Sea Link Energy Cable

**Appendix J4 to the Natural England Deadline 4 Submission**  
**Natural England's Comments on Kent Landfall**

Planning Inspectorate Reference EN020026

10<sup>th</sup> February 2026

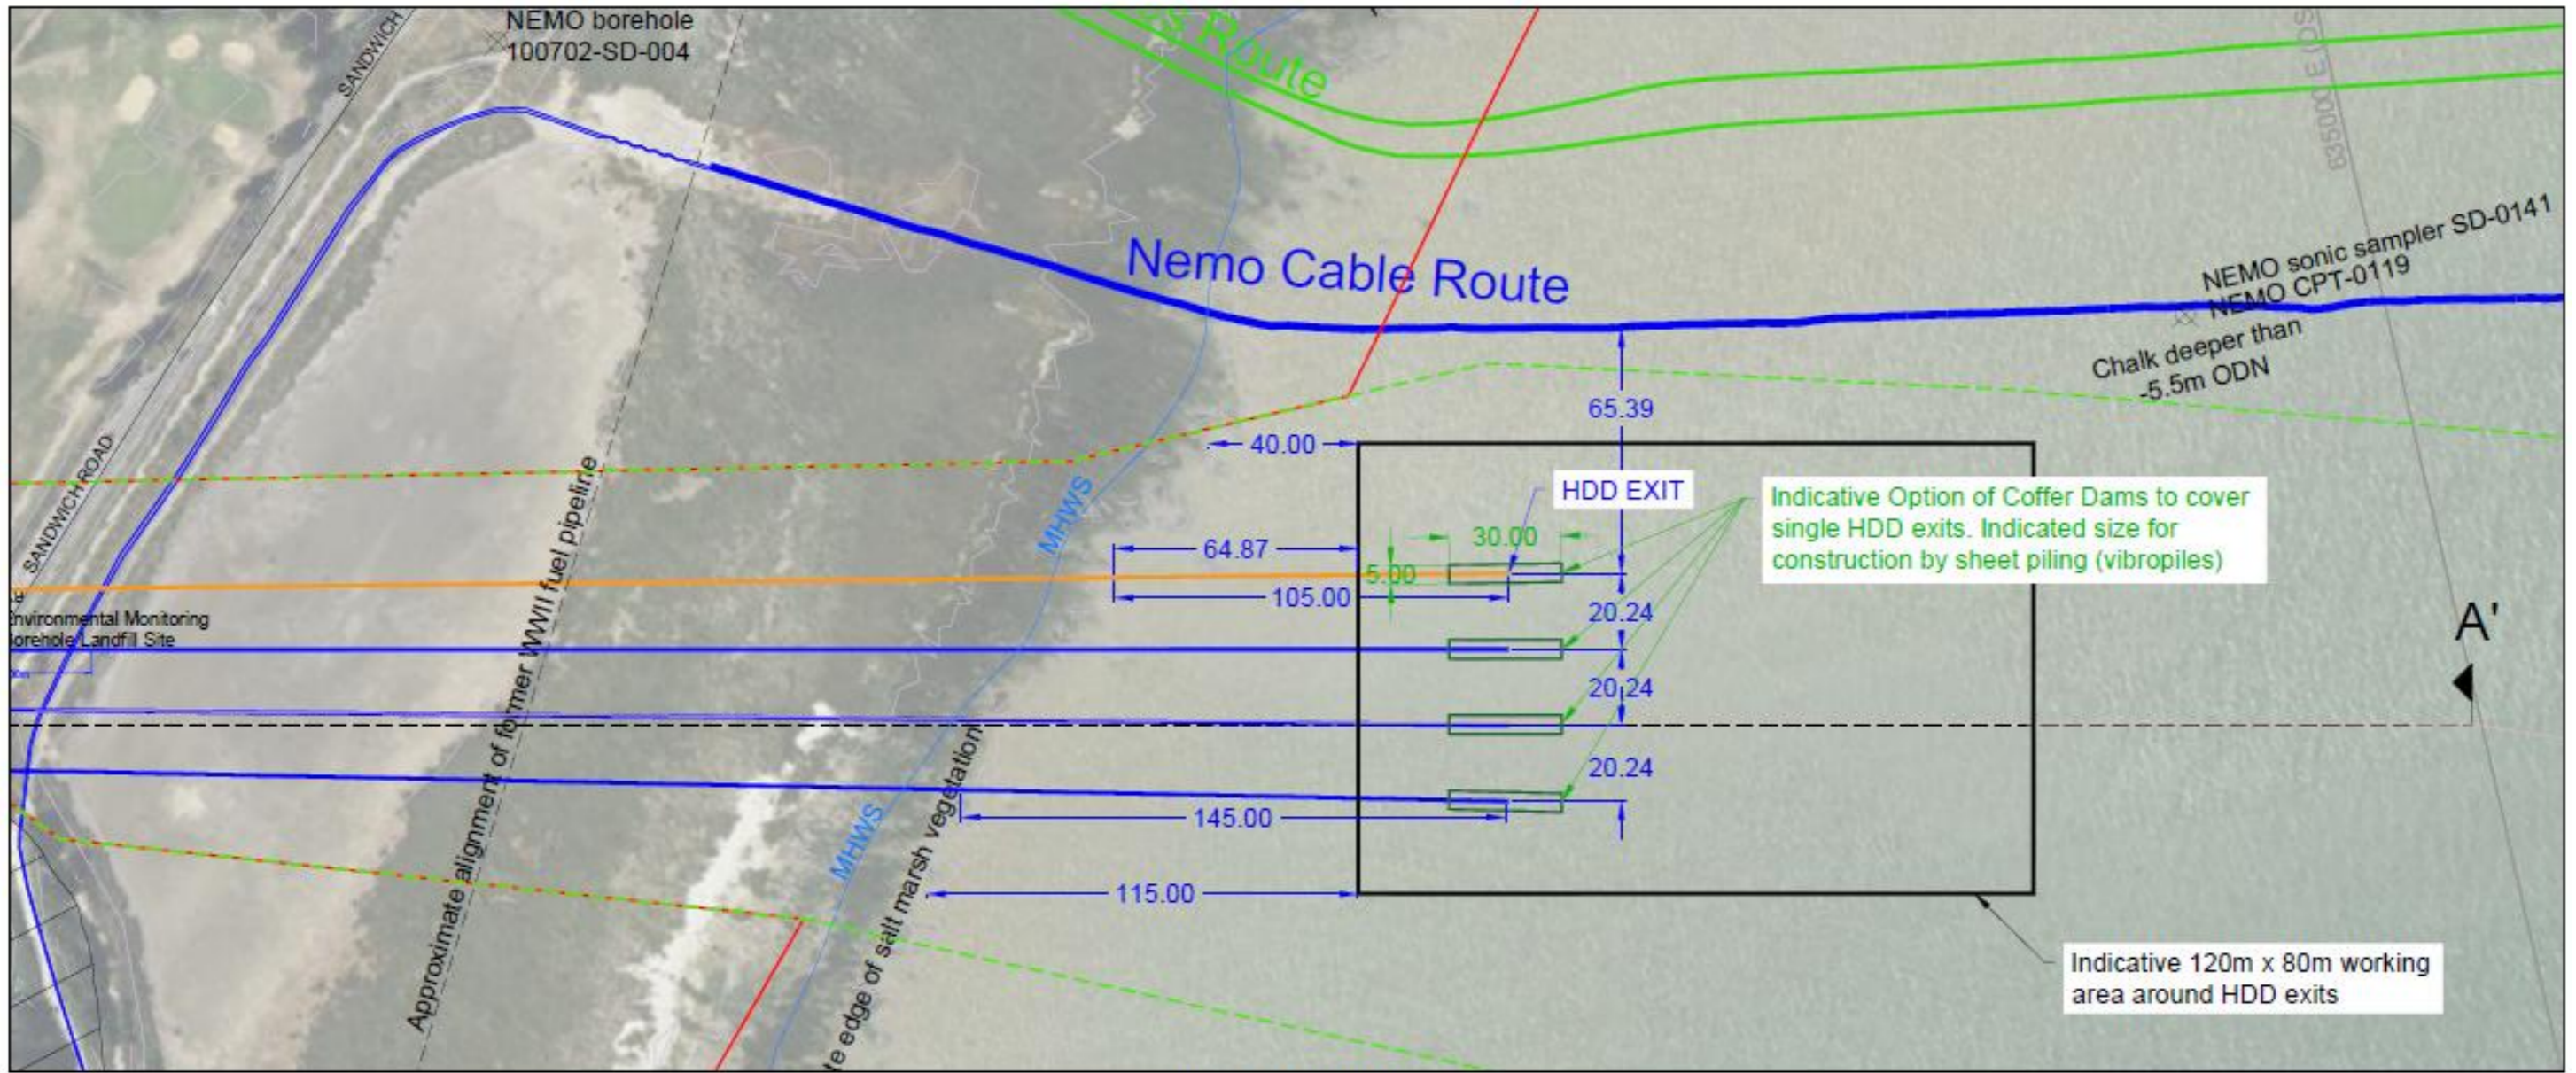
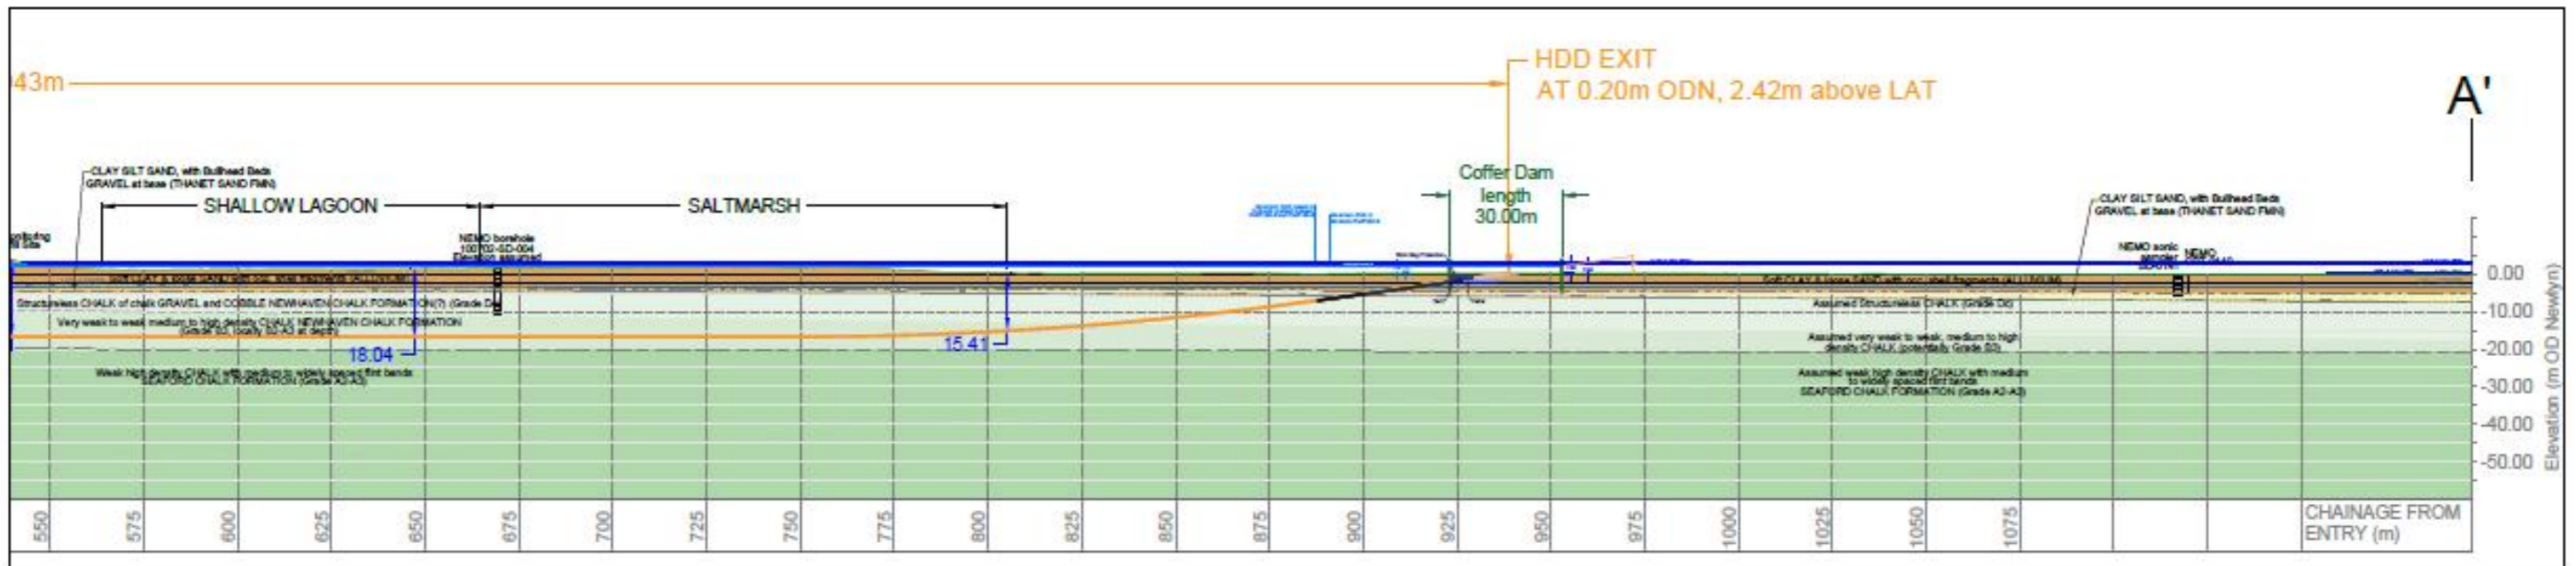
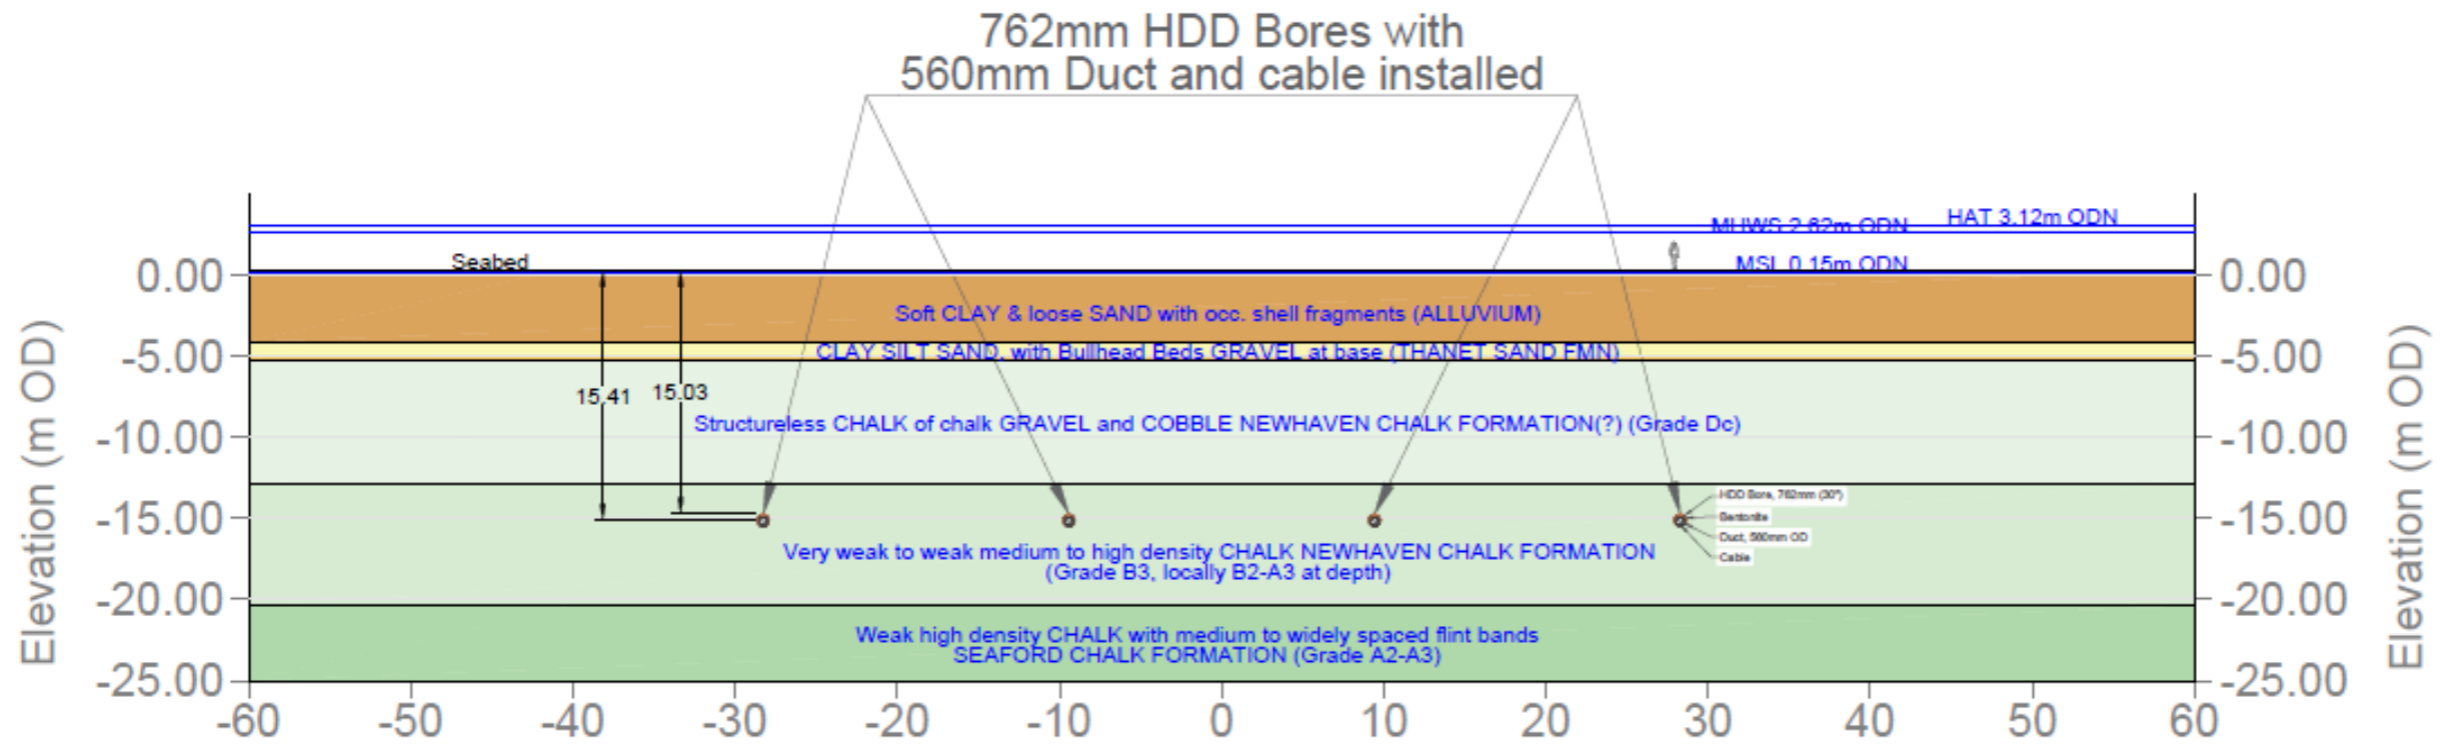
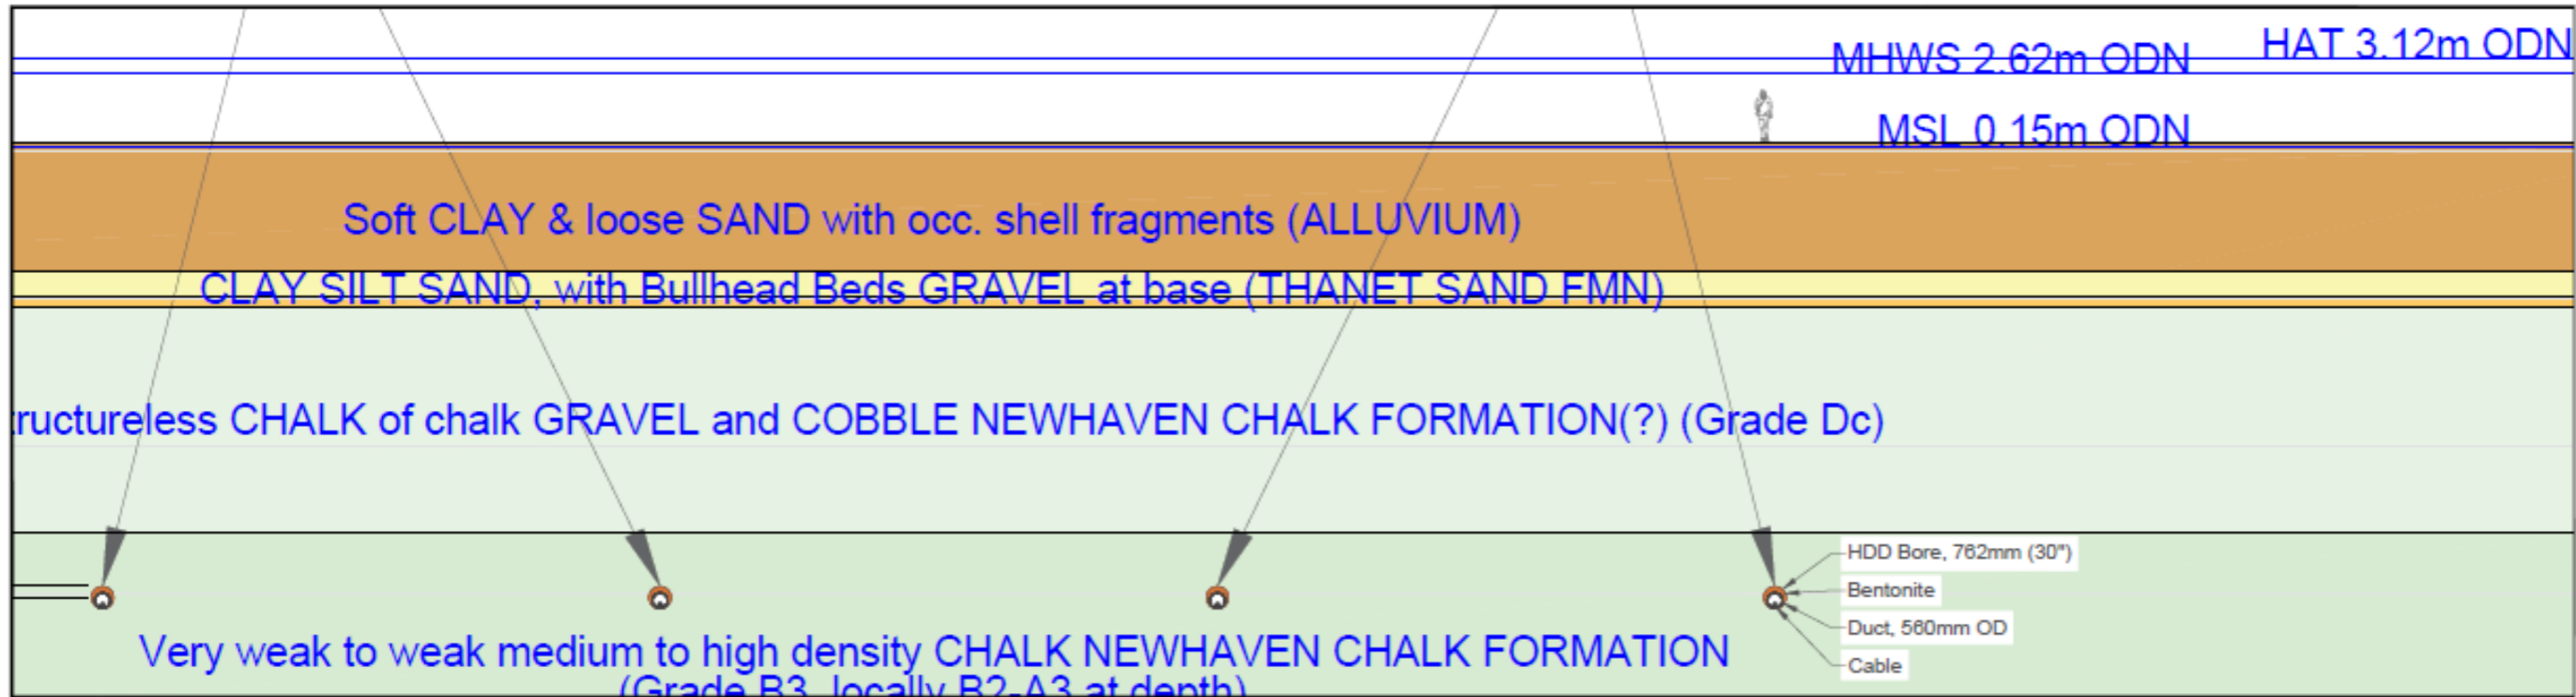
| 7  | B66 | Natural England has concerns that impacts to saltmarsh will not be avoided or mitigated with current proposals. | Natural England refers the Applicant to Appendix J3A of Natural England's Deadline 3A response [REP3A-028] and highlight that we do not believe that what has been proposed is sufficient to avoid impacts to saltmarsh habitats. We also highlight that in all other docs the commitments to avoid impacts to vegetation has been included. |
| 10 | B69 | Natural England is concerned that 50m separation between landfall works and saltmarsh is insufficient.          | Please see further advice in Appendix J3A of Natural England's Deadline 3A response [REP3A-028].   |
